ROZELLE VILLAGE DEVELOPMENT

ACCESS REVIEW

Morris Goding Accessibility Consulting

15th February 2012

LEVEL 2 PLAN
RL 48.72

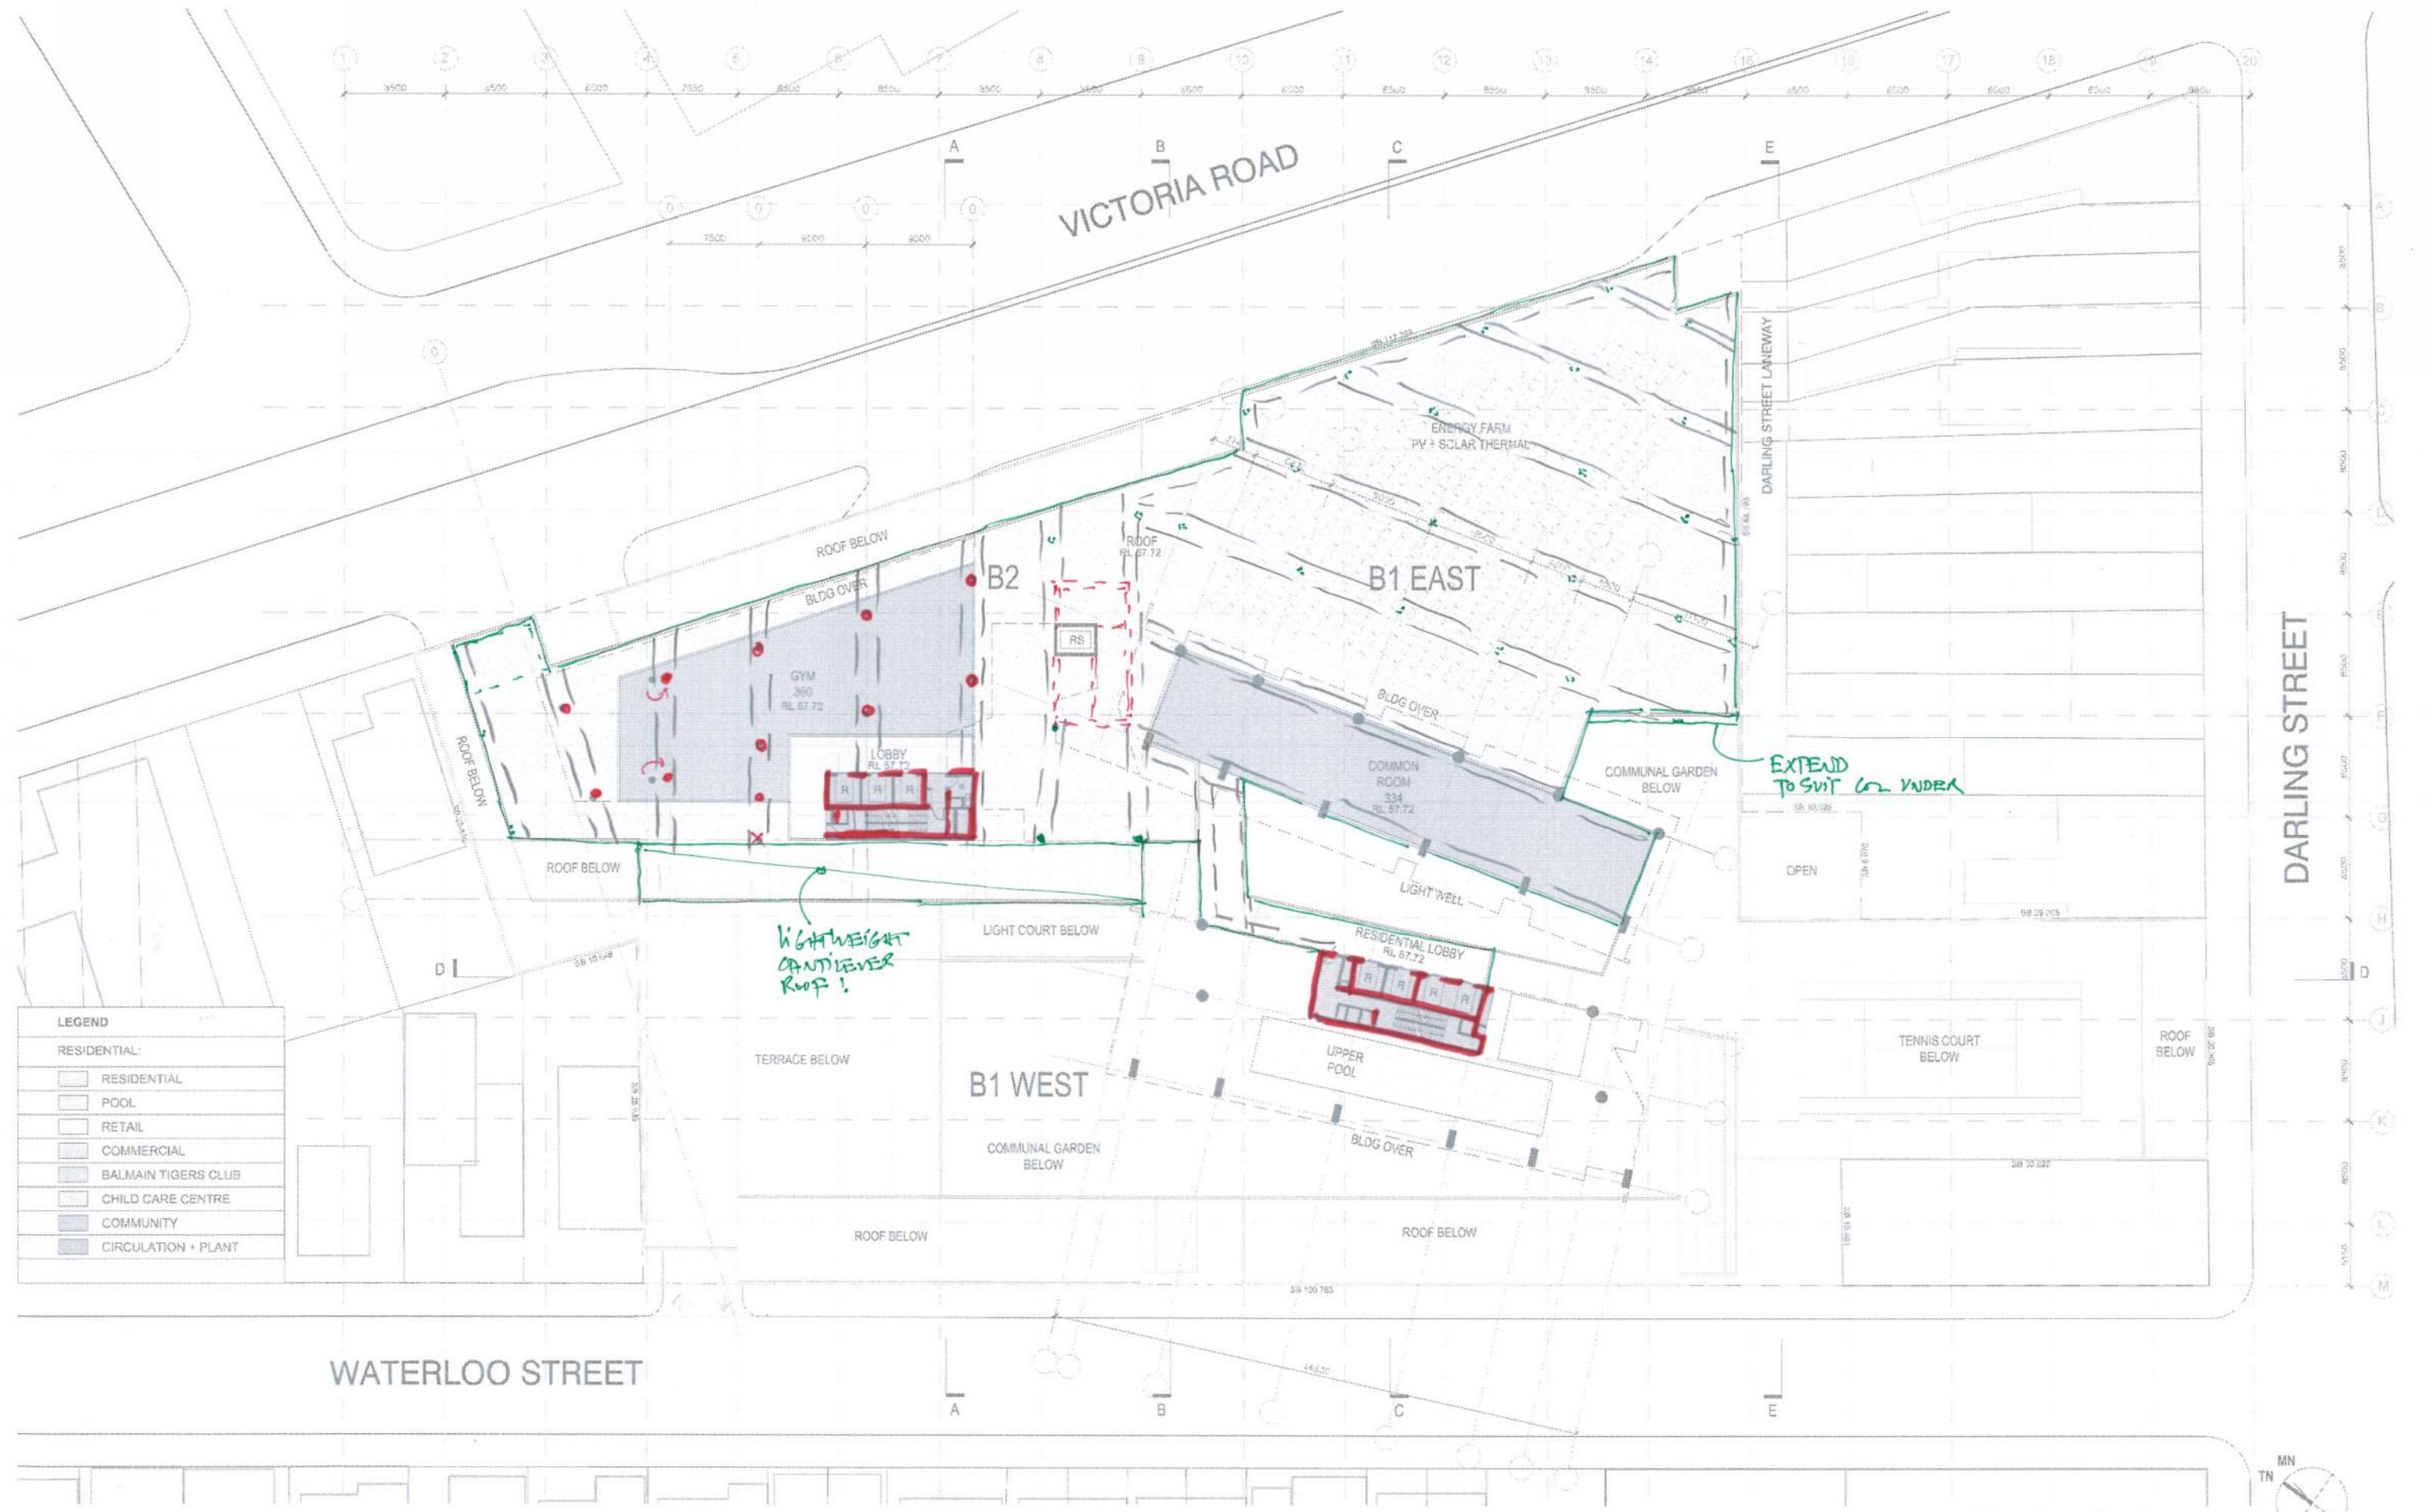
The dual hinged entry doors to Childcare Centre have less than 850mm clear width each, which requires review for compliance with AS1428.1. This is achievable.

- (i) Ensure all corridor ends provide a wheelchair turning area (1540mm width x 2070mm length) within 2m of the end, compliant with AS1428.1 and DDA Premises Standard.
- (ii) Provide entry doors with 850mm clear widths (920mm door leafs) and 510mm latch side clearance compliant with AS1428.1 & Leichhardt Municipal Council DCP No 32.
- (iii) Ensure internal stairs within Soho tenancies have handrails installed on both sides, compliant with AS1428.1.
- (iv) Ensure Childcare Centre terrace is accessible for people using wheelchairs, compliant with AS1428.1.
